**Sydney Children's Hospital Stage 1 and
Children's Comprehensive Cancer Centre (SSD-10831778)
Response to submissions**

Attachment 1

Drawing Title
**Turning Paths
Vehicle access to SCH1/CCCC B02
car park**

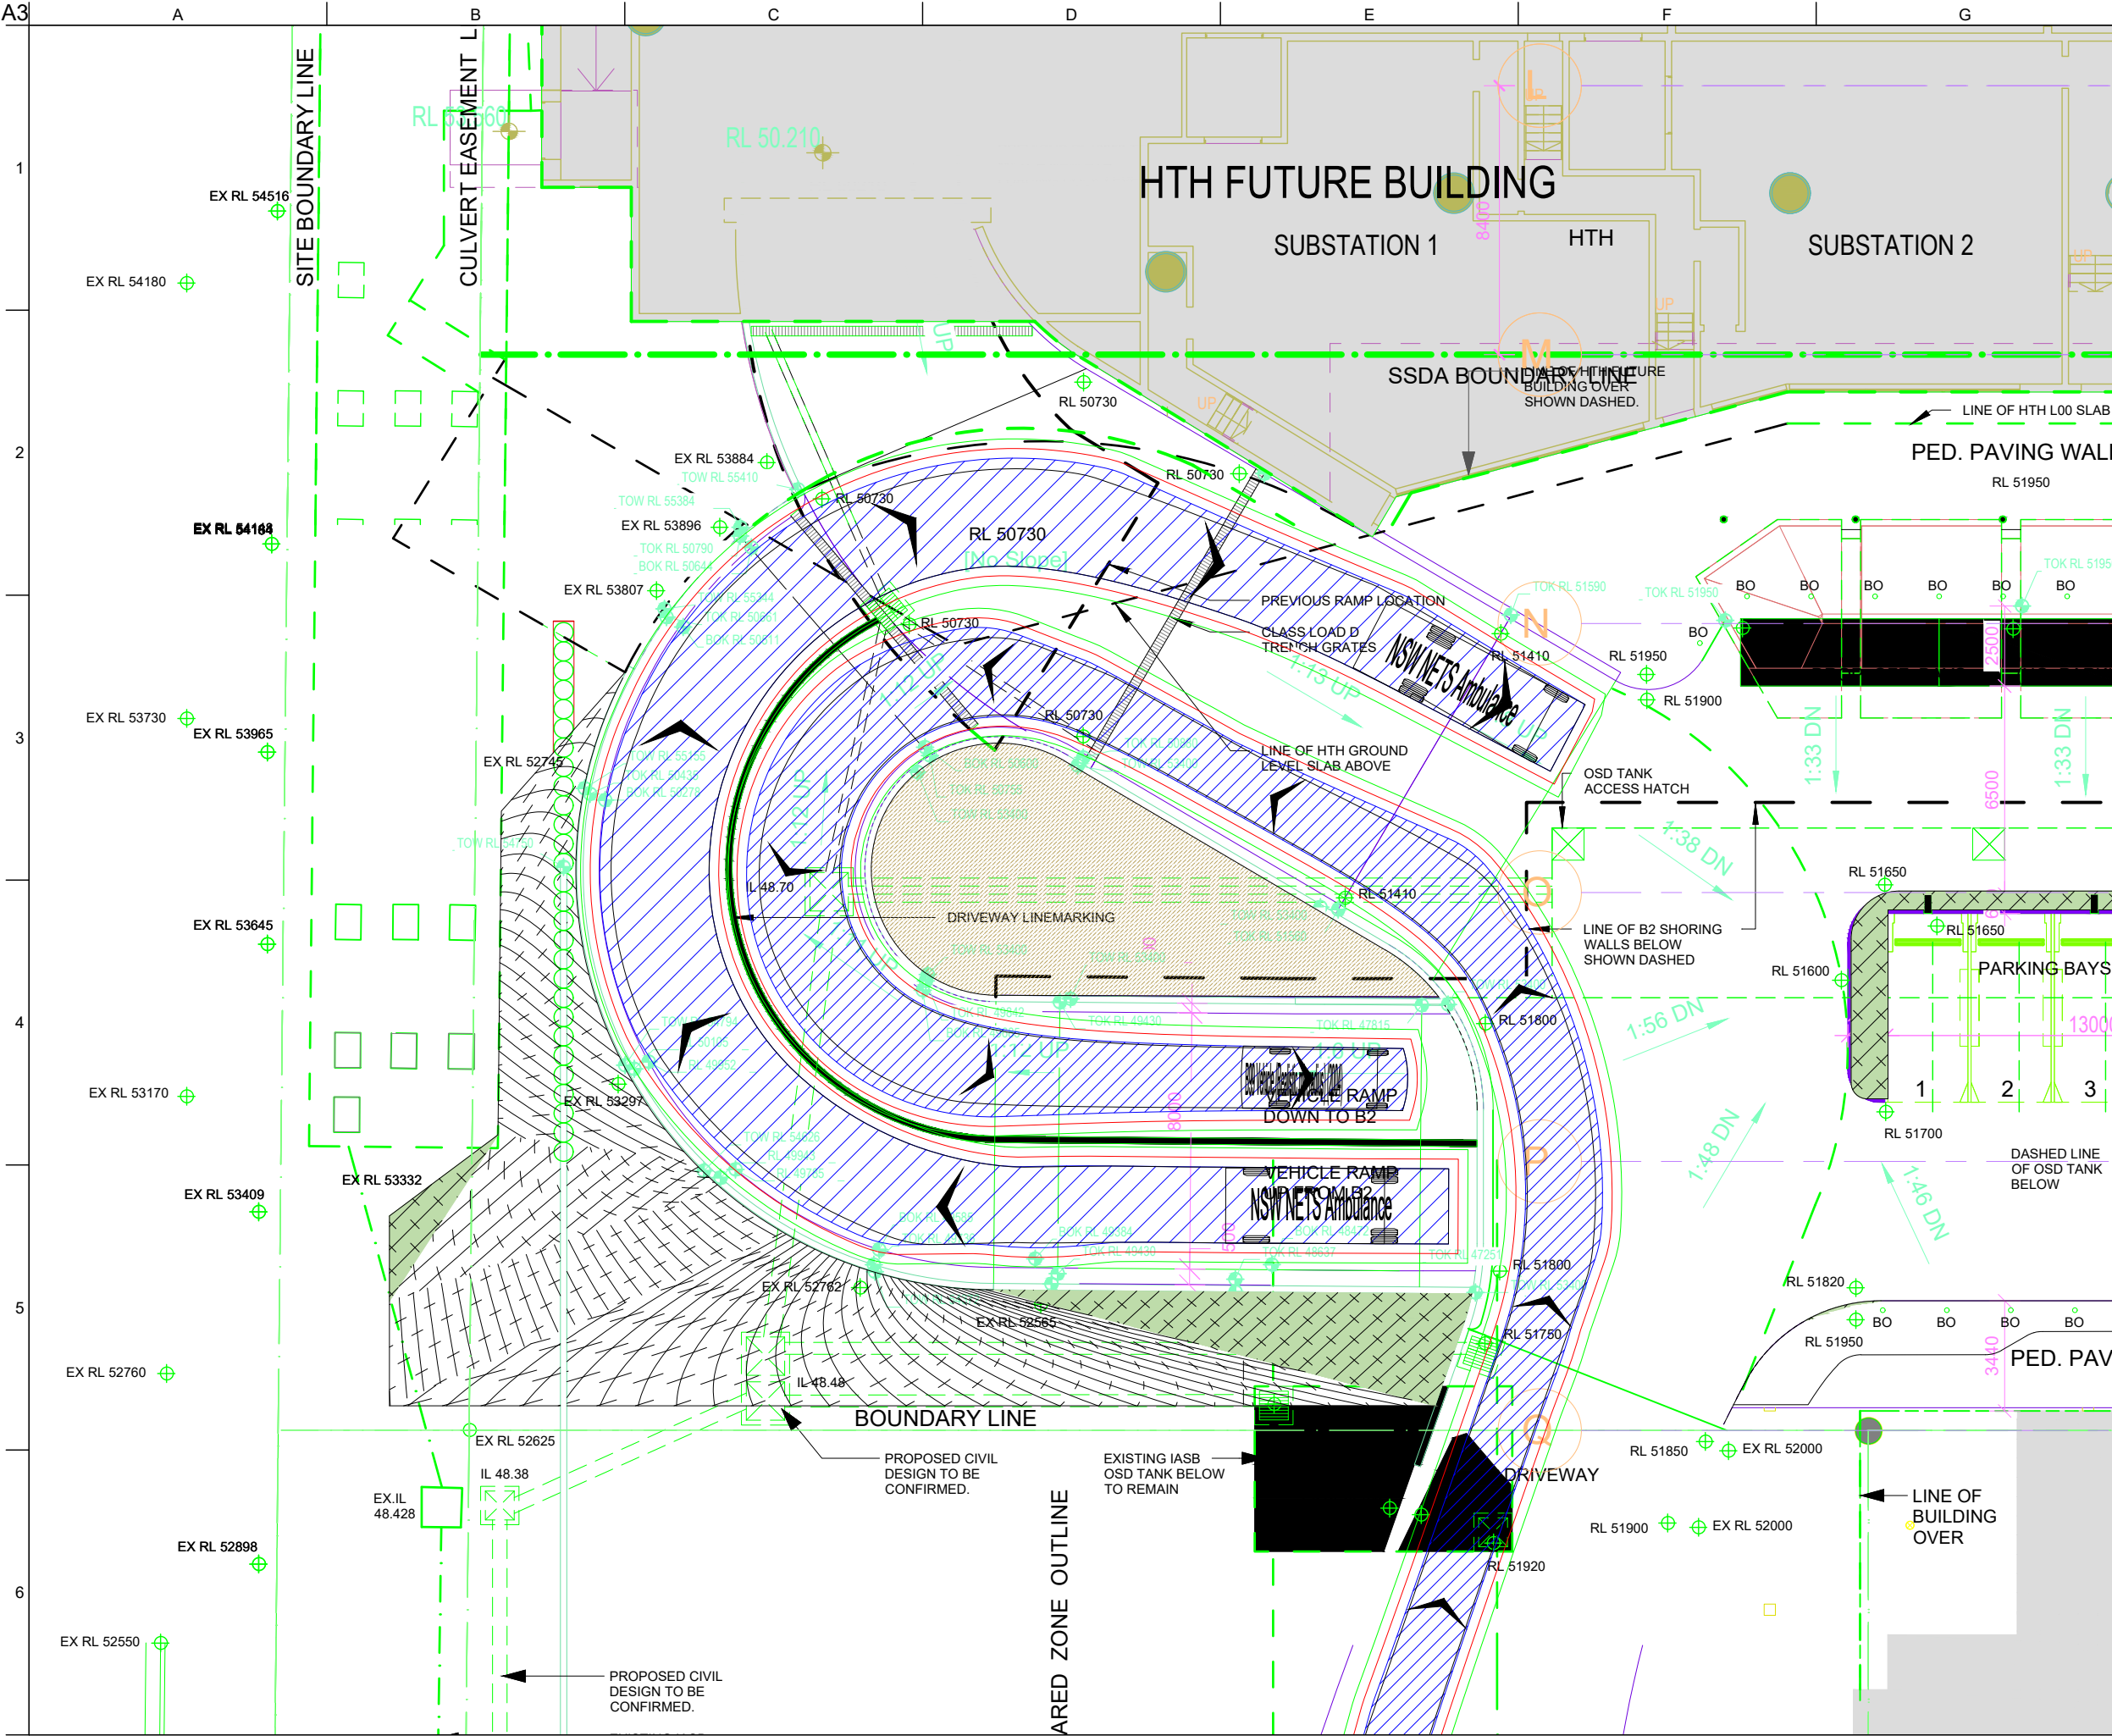
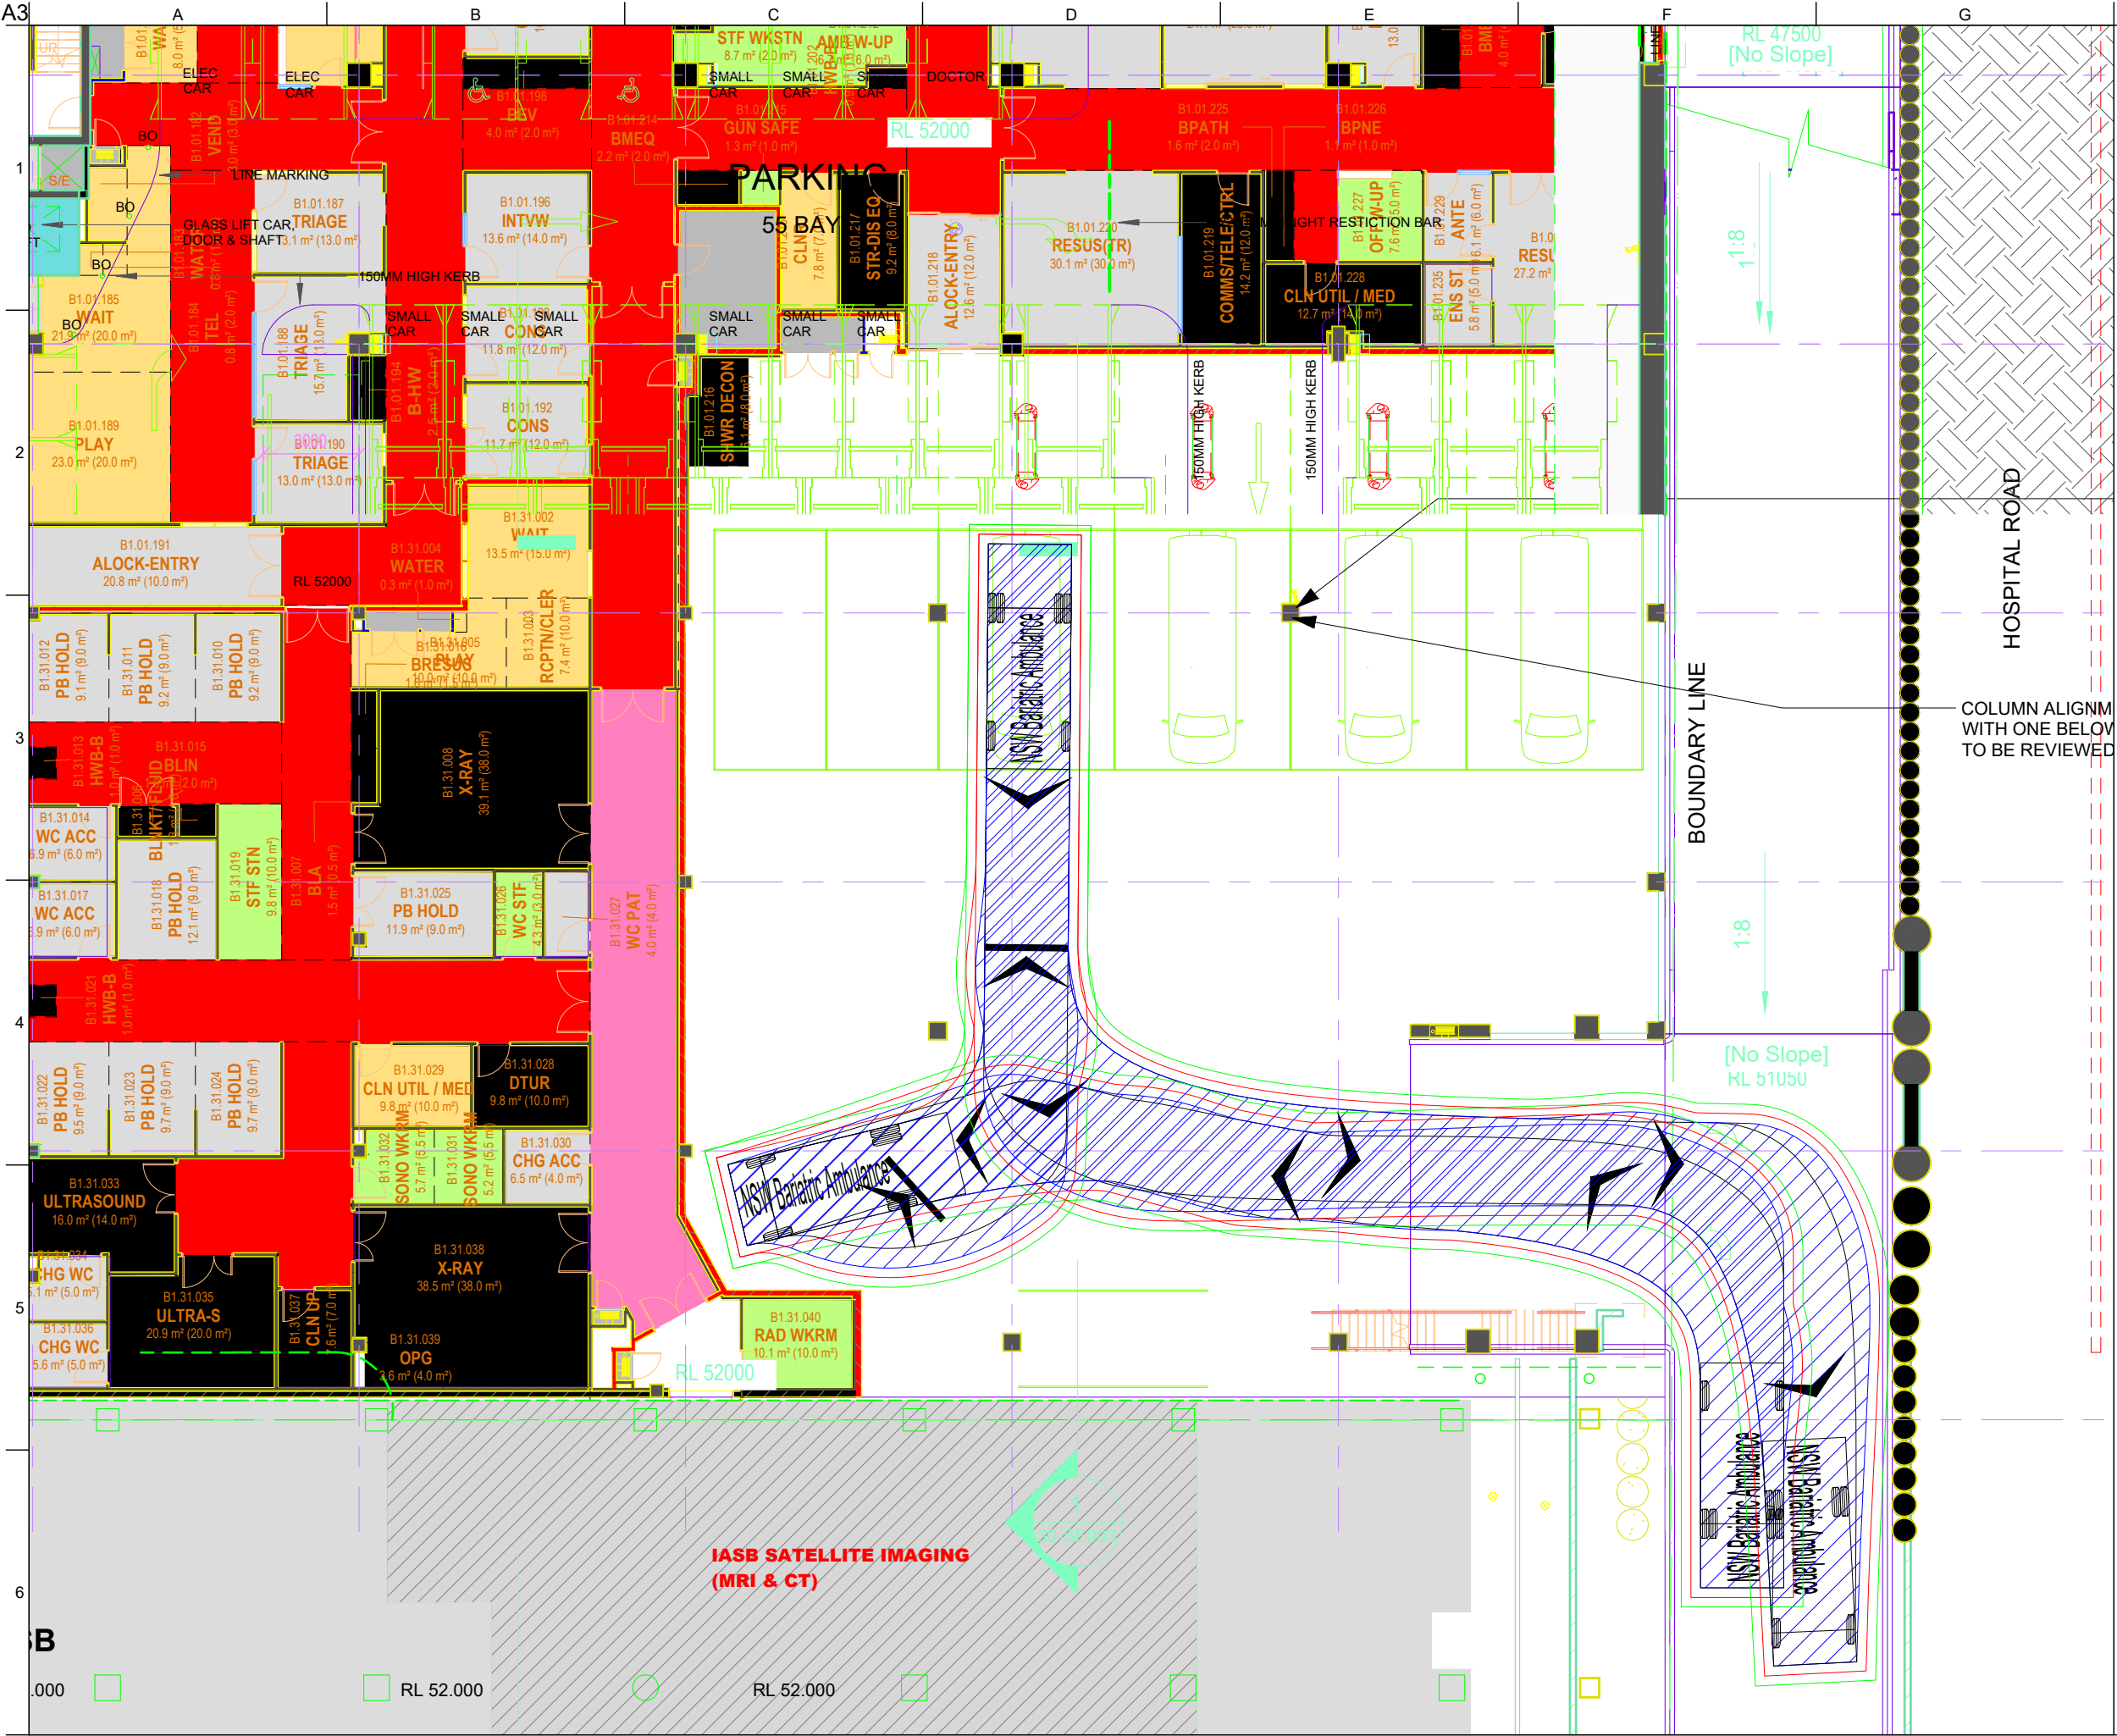
- Provide swept path diagrams and analysis for the largest proposed vehicle types at each vehicle entrance and loading bay area. Where necessary, revise the design to ensure swept paths are appropriate.
- Provide sections for all vehicle access ramps (including the enclosed Hospital Road) demonstrating adequate clearances are provided the largest proposed vehicles in accordance with AS 2890.
- Provide specific details of the proposed dynamic wayfinding system to be implemented in the main carpark and confirmation if, and how, these measures will be delivered to support the proposed development.
